DYLAN J. WILLIAMS BA (Hons), MSc, MA, M.R.T.P.I.
Pennaeth Gwasanaeth – Rheoleiddio a Datblygu Economaidd
Head of Service – Regulation and Economic Development

Dyddiad / Date: 19/09/2018

Review of Horizon's DCO Application (Temporary Worker Accommodation Campus)

Figure 2-1 Indicative Construction Timeline

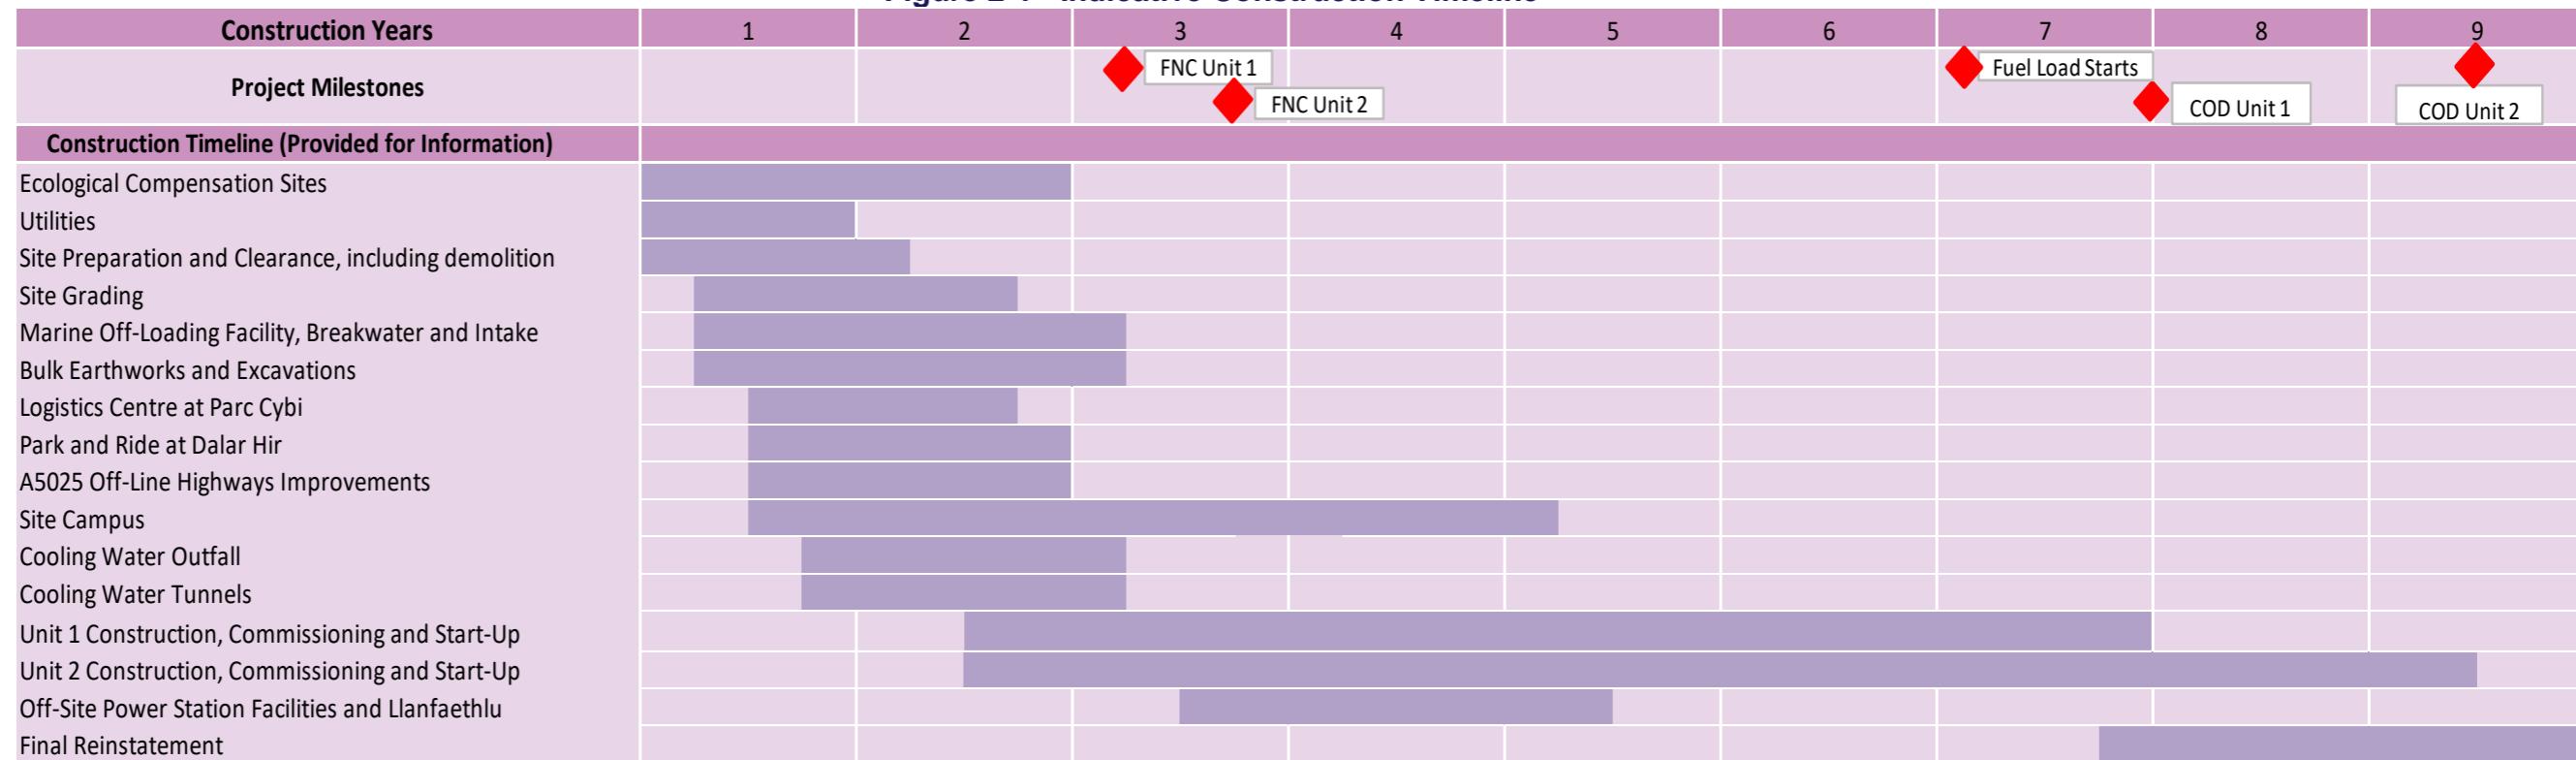
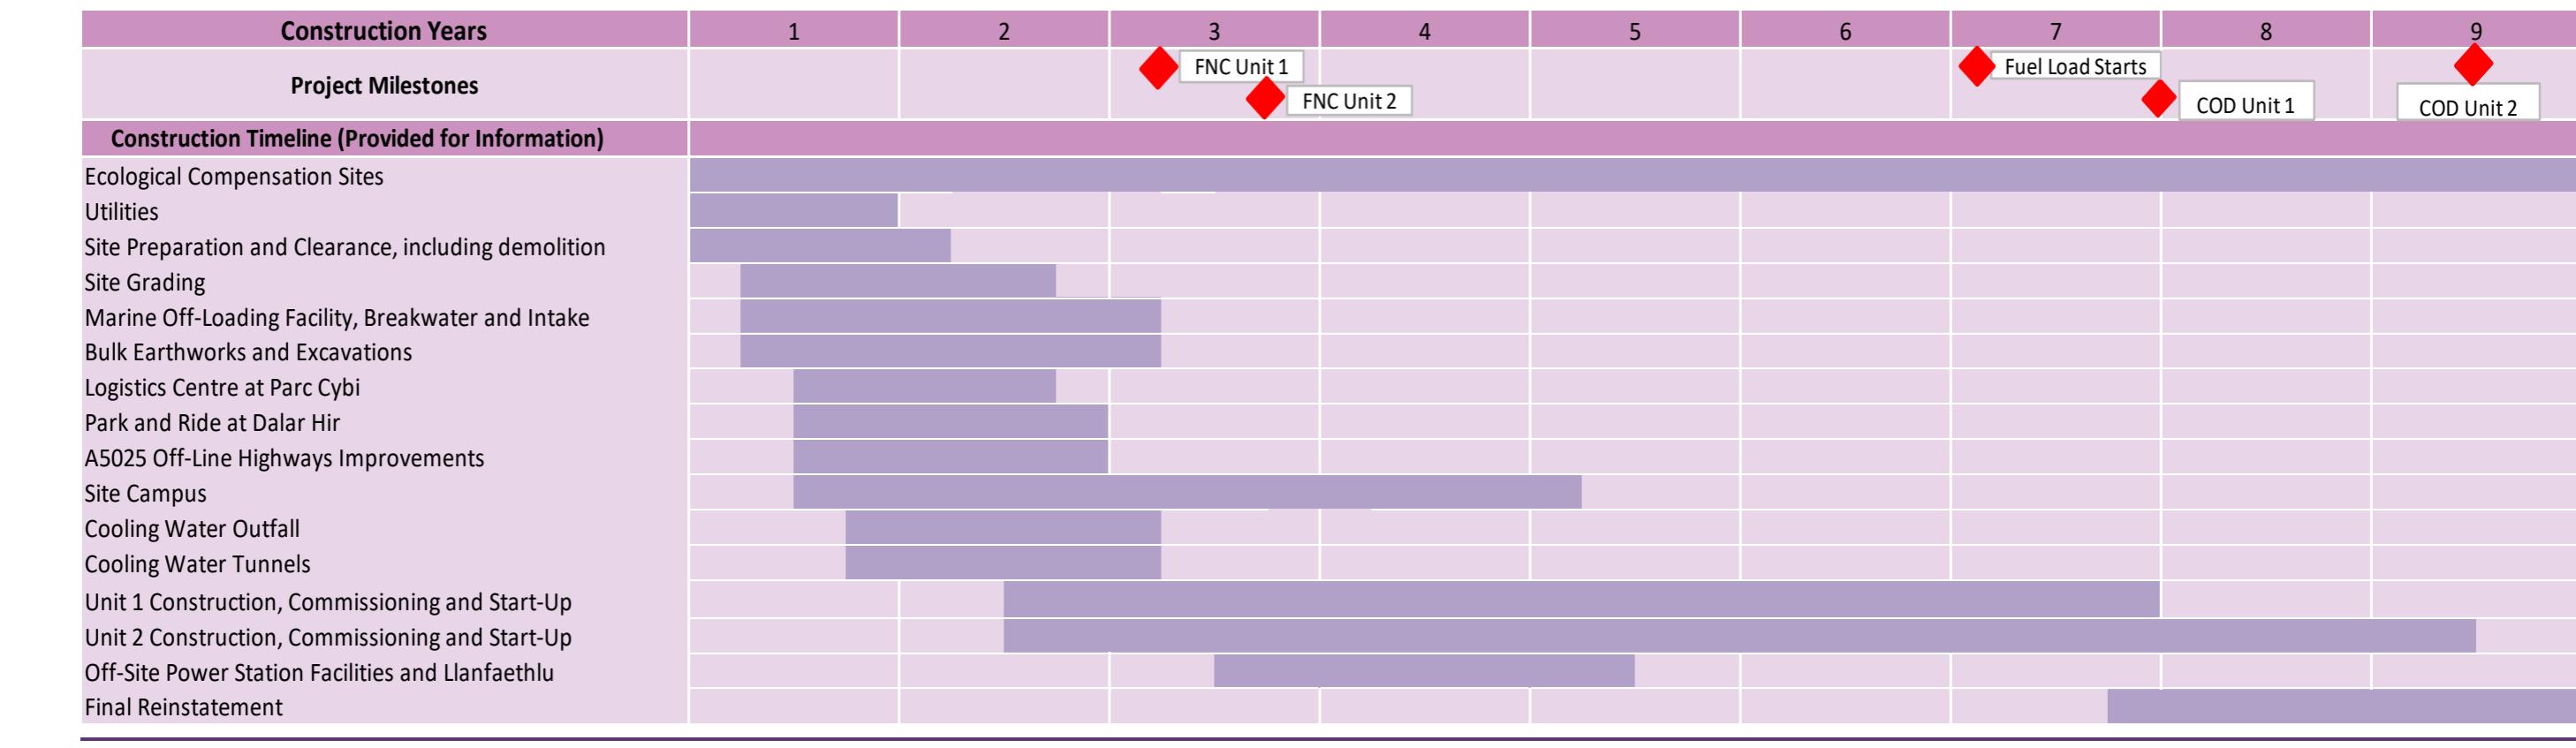
- **Phase 1** (1,000 workers) is completed and operational by end of Q2 year 3 (to coincide with start of Unit 1 Construction, Commissioning and Start-Up);
- **Phase 2** (2,500 workers) is completed and operational by Q3 year 4 (to coincide with construction worker profile in Jobs & Skills Strategy – i.e. increase in workers Q4 year 4 from approx. 3,000 to 5,000 workers);
- **Phase 3** (3,000 workers) is completed and operational by end of Q4 year 4.
- **Phase 4** (4,000 workers) is completed and operational by end Q1 year 5 (in accordance with Horizon's Phasing Plan (Figure 2-1).
